Reference: EP/149/14/PL

Proposal: Construction of 3 bedroom dwelling with rooms in roof space. Resubmission of EP/100/12.

Location: 37 Orchard Road, East Preston, BN16 1RB.

Existing Street Elevation

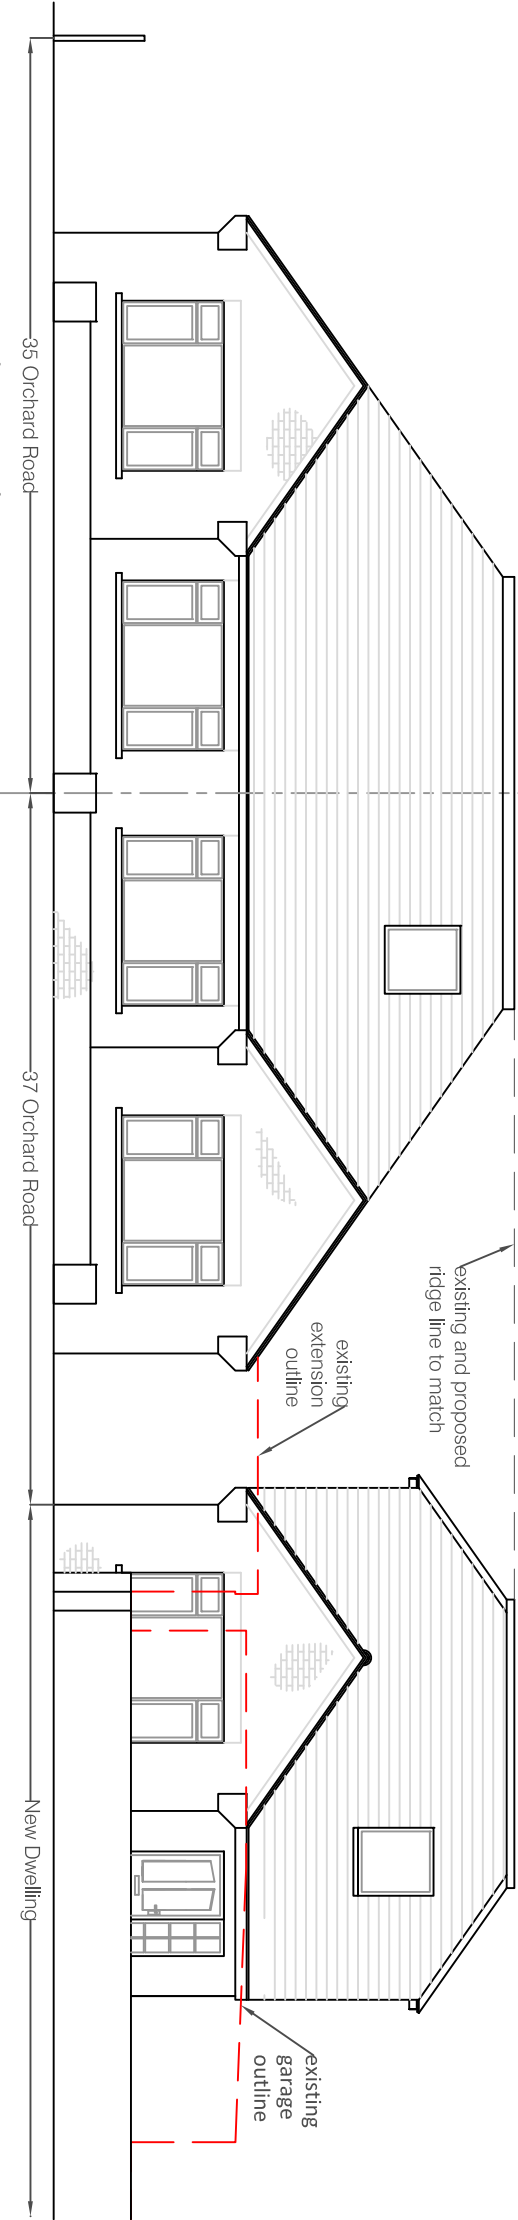
The new Design Statement declares there is a mix of one and two storey properties in Orchard Road but that is not true of the south side where 37 is located. There are only semi-detached or terraced bungalows and where there are dormer windows they are all set back within the roofline of the existing bungalows. There are certainly no first floor extensions at the back of any property along the south side of Orchard Road and no houses visible from Windlesham Gardens. A new property which has been turned sideways to fit onto a site which is too small for further development may look like one half of a semi-detached bungalow from the front but it will still look like a house from the rear.

This new proposal whilst having made some modifications would still look cramped and out of place with the surrounding properties. It would conflict with policy D DM1 of the emerging Arun Local Plan and also policy GEN7 of the Arun District Local Plan as well as the East Preston Village Design Statement.

Rear Elevation (south)

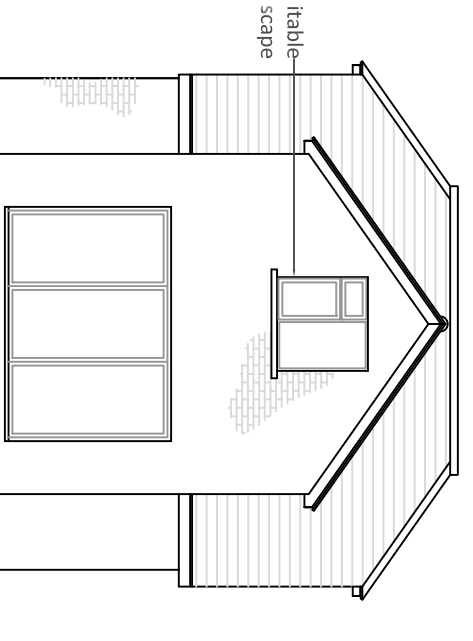
This resubmission attempts to address the original reasons for refusal both by Arun District and by the Secretary of State but it is still trying to shoehorn a 3 bedroom detached property into a space currently occupied by an enlarged single garage. Although attempts have been made to create further space by suggesting demolition of part of the existing extension at the rear of 37 it also proposes to set the new building further back from Orchard Road. This means that the rear wall will be even closer to 3 and 4 Windlesham Gardens than in the previously rejected plan. It is further proposed that this wall will have a barn end style which will make it look exactly like the end of a house. It will have a lower window but also an upper window directly overlooking the bedrooms and kitchens of 3 and 4.
